Application No: M/7/26/HH  
Site Address: 1 Harefield Road Middleton-on-sea PO22 6EB  
Description of works: Two storey side extension, installation of front and rear dormers and alterations to fenestration, following the demolition of existing side garage and removal of existing side dormer.

Thank you for your internet representation made on 30th April 2026 which has been recorded as an objection with the comments as follows:

Proposed Side and First Floor Extension Site Location Planning
Date August 2024
Scale 1:200 1:1250

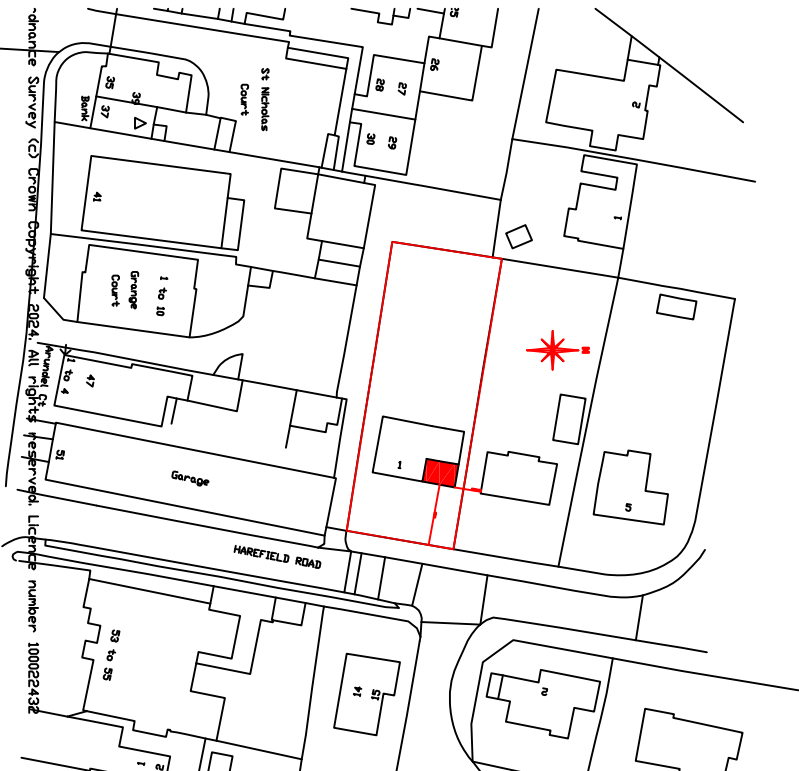
Secondly, there is concern regarding the planning drawings and site layout submitted. The application appears to show the bungalow as benefiting from a larger adjoining plot of land than exists in reality. On the immediate left-hand side of the bungalow, the land is not open space belonging to the property, but is occupied by four garages currently operating as a mechanics business and caf . This gives a misleading impression of the available space, setting, and relationship with neighbouring uses. I ask that the accuracy of the submitted plans and site boundaries be carefully reviewed.
